**WEST SUSSEX COUNTY COUNCIL
STRATEGIC PLANNING CONSULTATION**

SUBJECT: Y/99/13 - Outline application for 10.5 hectares of residential development (comprising up to 250 dwellings (30% to be affordable) together with ancillary open space and landscaping), 14.9 hectares of public open space development to be laid out as public parkland and landscaped green corridors, vehicular access from Ford Lane (The means of access) - This is a Departure from the Development Plan.

LOCATION: Land North & East Of St Marys Church, North End Road, Yapton, West Sussex

This is the second WSCC highways and transport response to the planning application and follows assessment of the application submission including Transport Assessment and Travel Plan.

K Langmead
St Mary's Park North End Road Yapton
Proposed Indicative Layout, Strategic Landscape & Open Space Proposals
SCALE 1/2000 @ A1
Drawing number 102C

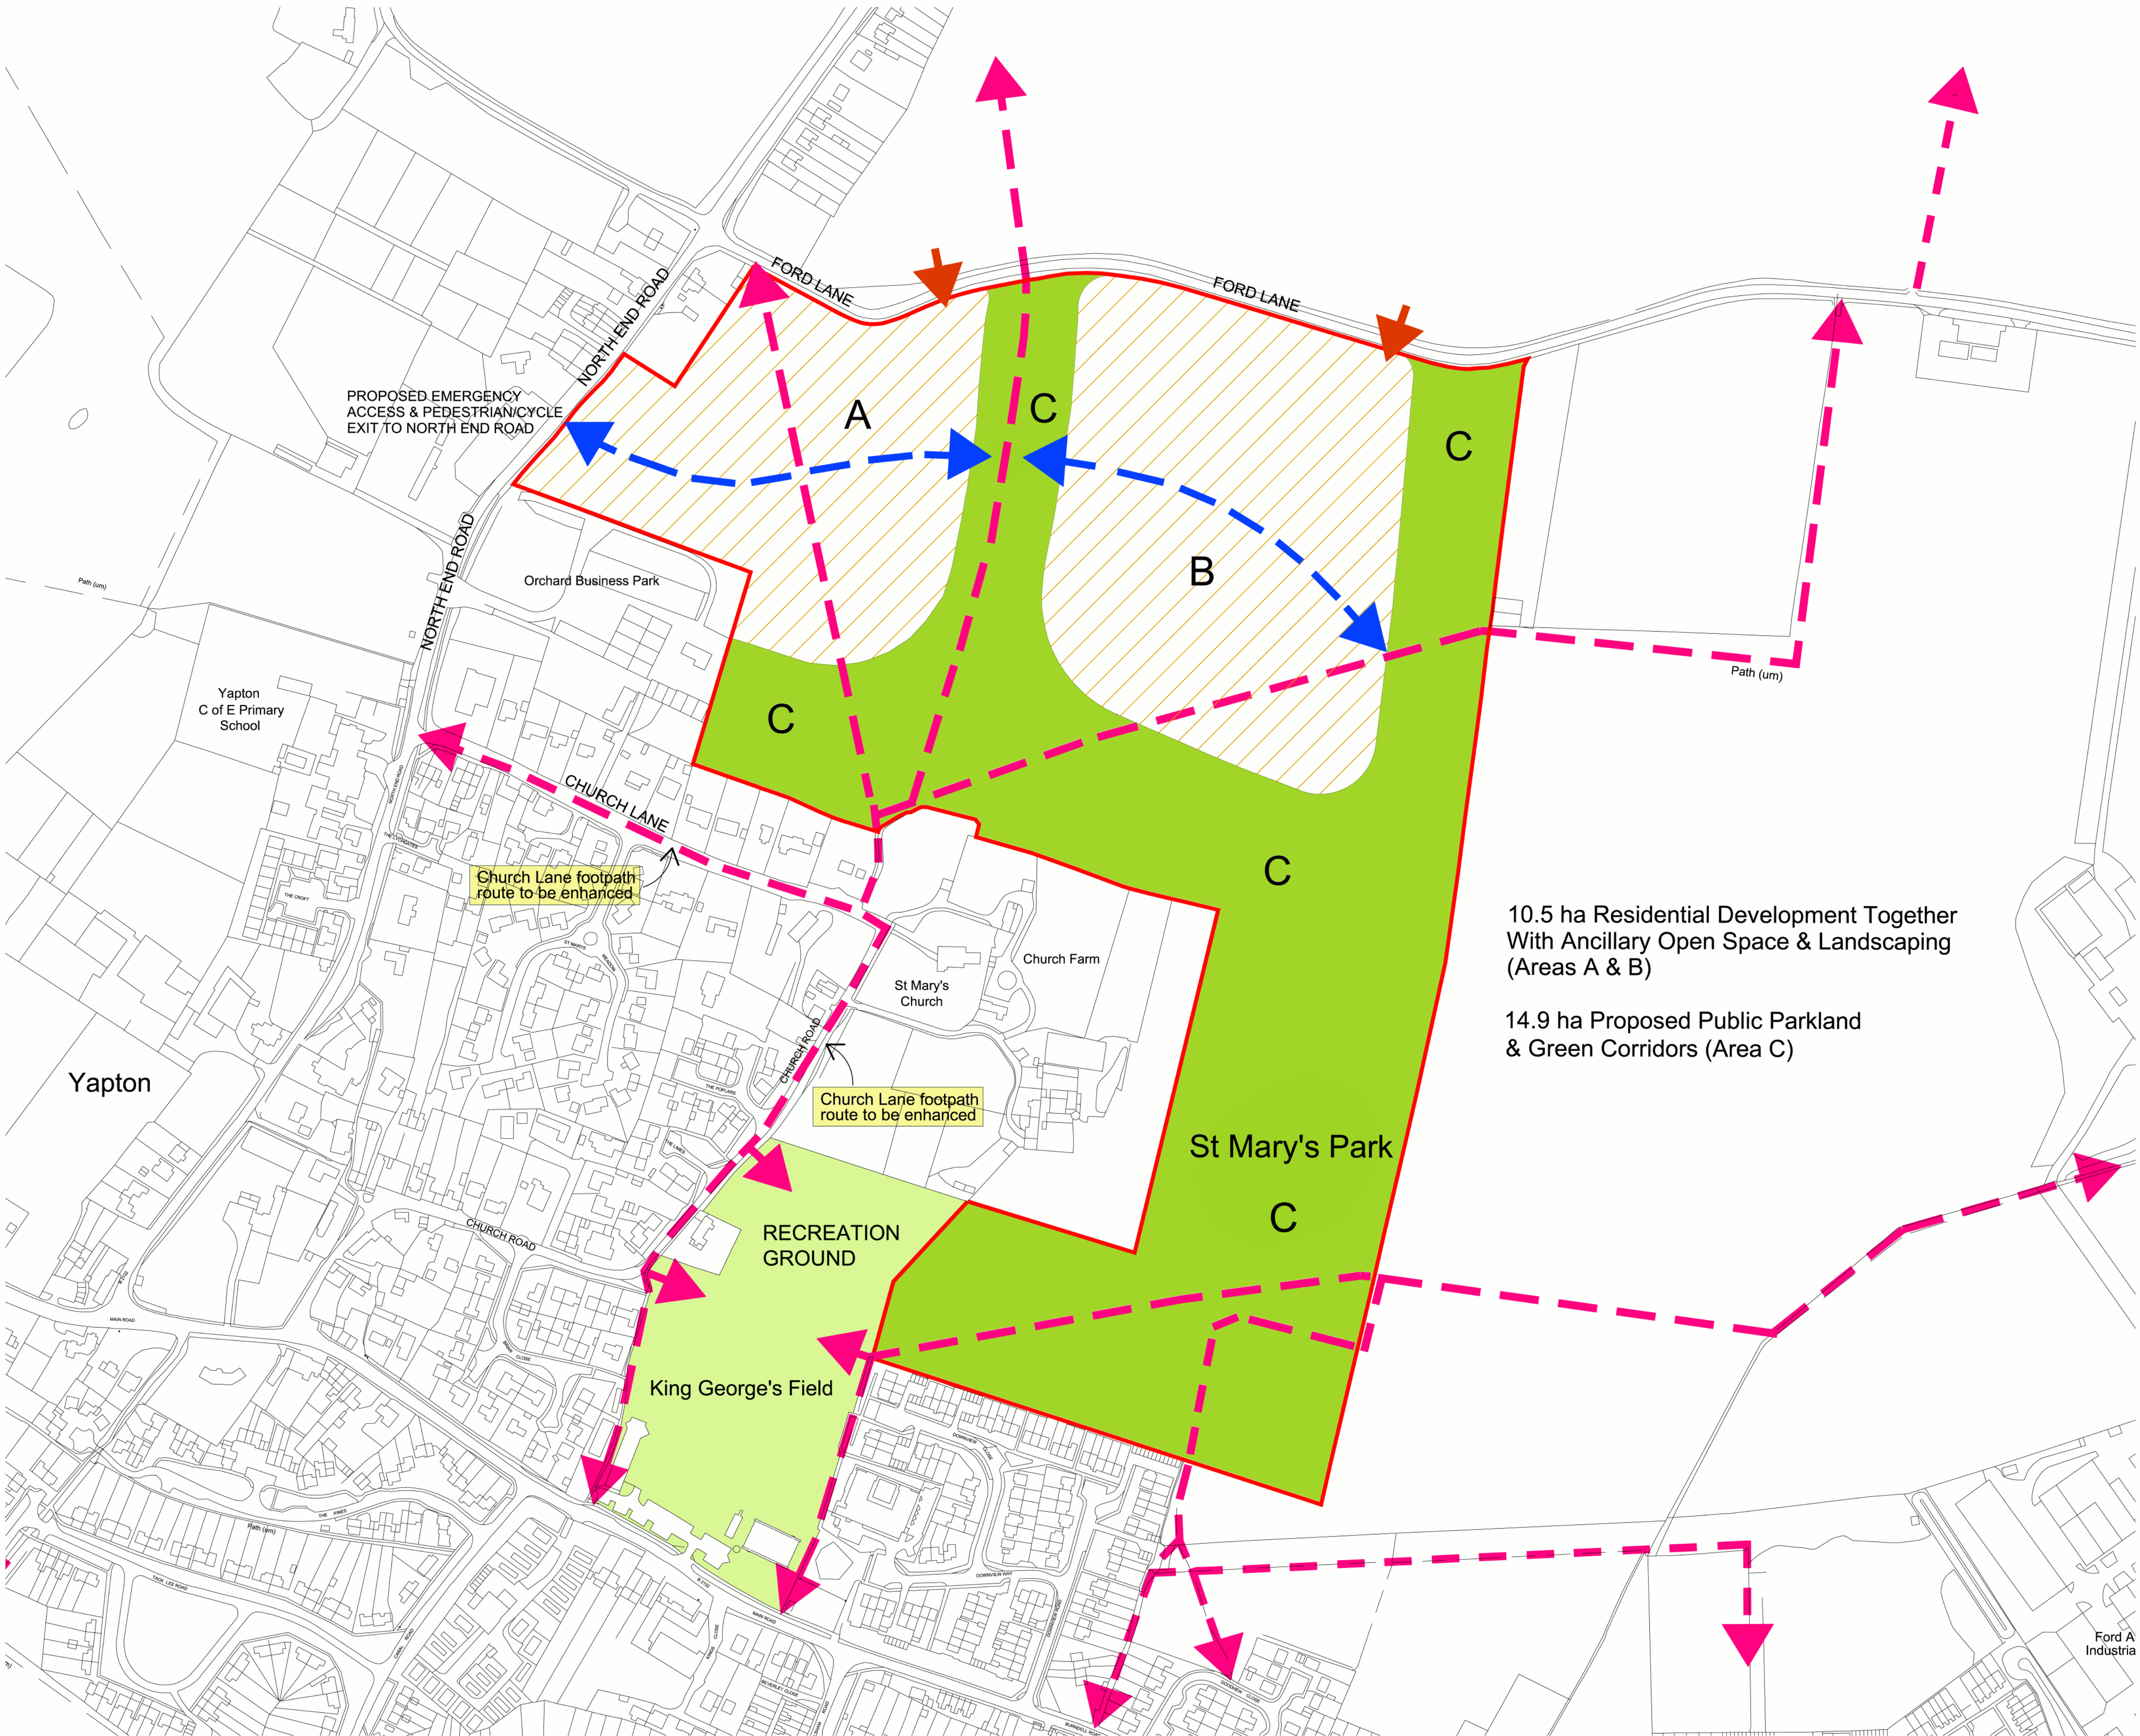
Cycling – An indicative route is shown on application drawing 102C. This will be considered further at any reserved matters stage. However, the site will also be expected to provide further links north-south through the site connecting to routes providing access to Main Road and Burndell Road. Parts of these could be accommodated on quiet roads within the scheme. However, the preference would be for a more formalised network of high quality routes away from access roads leading through the site from Ford Lane and North End Road and then towards Church Lane, with connections to King George Recreation Ground and through to Main Road and Burndell Road. Links should also be provided through the eastern part of the site and through to King George Recreation Ground (annotated as ‘St. Mary’s Park’ on one of the application drawings). A link through to that approved under Y/81/10 would also be beneficial. All changes and/or connections to formal PROW will have to be approved by the PROW officer and, where required, the PROW Committee.

Plan 102C provides annotation stating that Church Lane will be improved as part of the planning application. No detail is shown. As such, more information should be provided.
